17 December 2019

Attention: Director – Social & Infrastructure Assessments
Application number: SSD-9673

Re: Randwick City Council submission on the State Significant Development SSD-9673 – University of NSW Kensington Campus - Redevelopment of the Chancellery building

Client	UNSW	Drawn	GF   BP	Scale	1:250 @ A1	Dwg.	S18046_SSDA-003	
Architect	3KN	Checked	SC	Date	13.09.19	Rev.	DRAFT

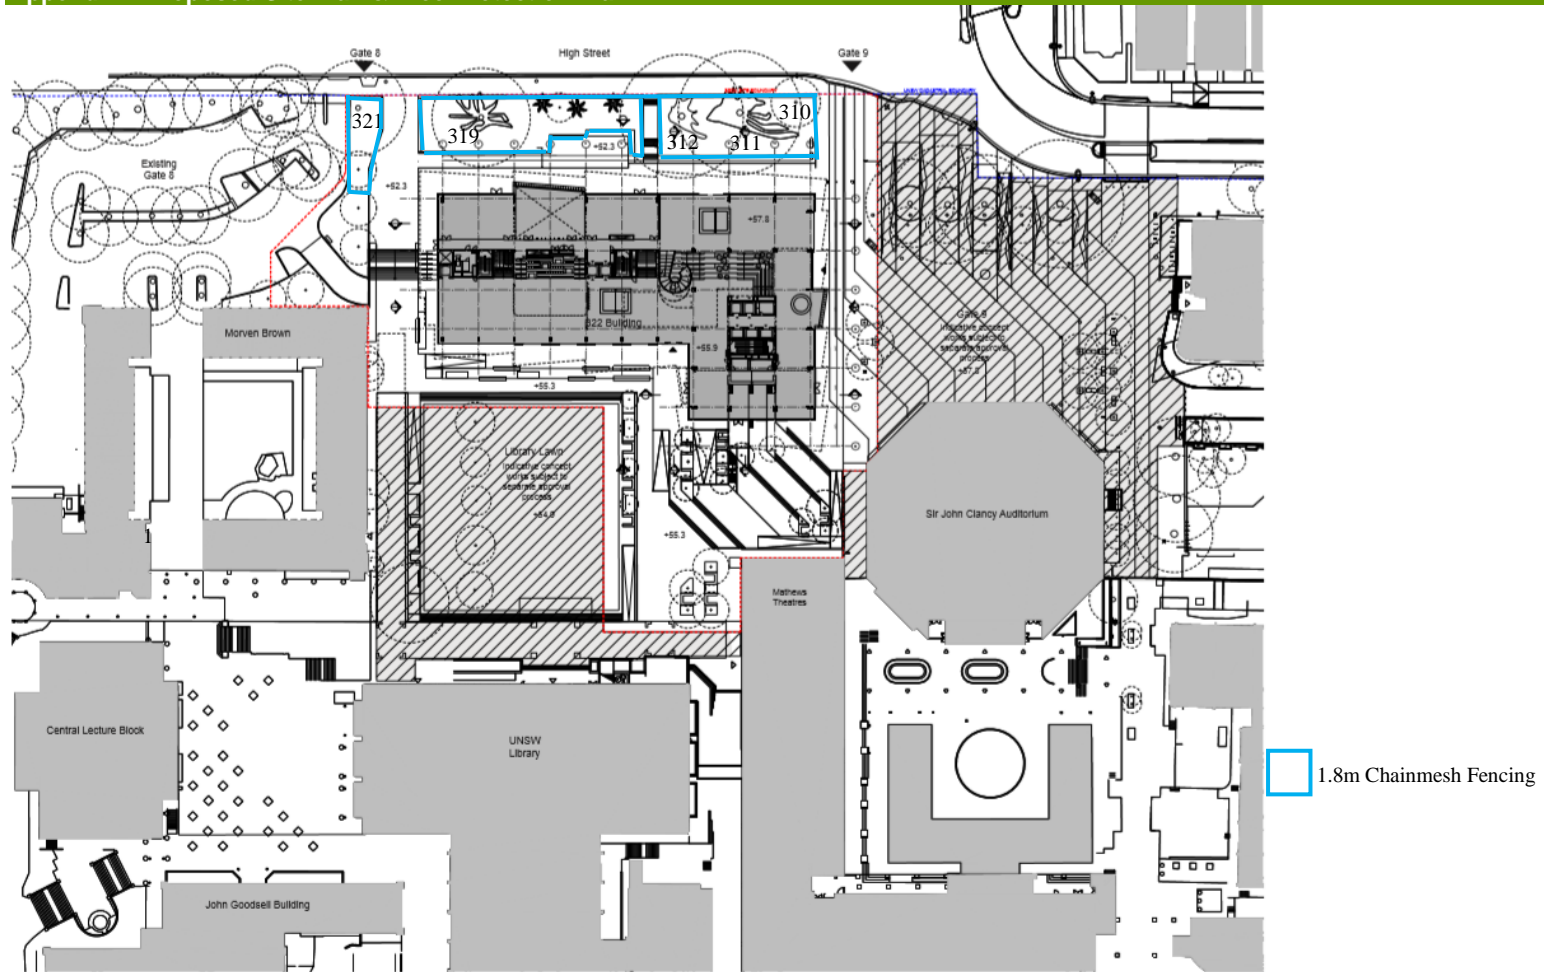
24. The submission seeks the removal of eight trees, comprising:

- T007, a 5m tall Bottlebrush towards the northwest site corner;
- T309, a stand-alone, 15m tall Brown Pine near the northeast site corner,
- T320 & 322-326, 15-20m tall Tallowoods, along the western boundary, near the northwest site corner, which while having a presence due to a combination of their size and quantity, are a common, non-endemic species.

25. Consistent with past advice, due to the scope of works involved with this SSD, none of these trees will pose a material constraint, with the replacement strategy for the loss of these 3 small trees and 5 large trees nominated to be 2 medium sized trees and 5 large canopy trees, which (in time), will result in a net-gain of overall canopy cover, so is considered an acceptable outcome as all of these trees are deemed the least significant of those that are in and around the works zone.

26. The 5 listed for retention are:

- T310: a 9m tall Brown Pine towards the northeast site corner, which will minimise any loss of amenity along the streetscape arising from the removal of T309, which is just to its east;
- T311-312 & 319: three mature Moreton Bay Figs, of enormous dimensions of between 14-20m x 16-25m, which are the dominant feature of this entire streetscape, and are all included in Council's Register of Significant Trees as Items 35 aai – aak;
- T321: a mature, 16m x 16m Hills Weeping Fig, right in the northwest site corner, which is listed as an 'associate planting' in the Significant Register, so also contributes to the presence of significant trees along this frontage.

27. Consistent with past advice, the strategic retention of these 4 most significant trees is non-negotiable and will be possible based on the information provided, with relevant protection measures provided.
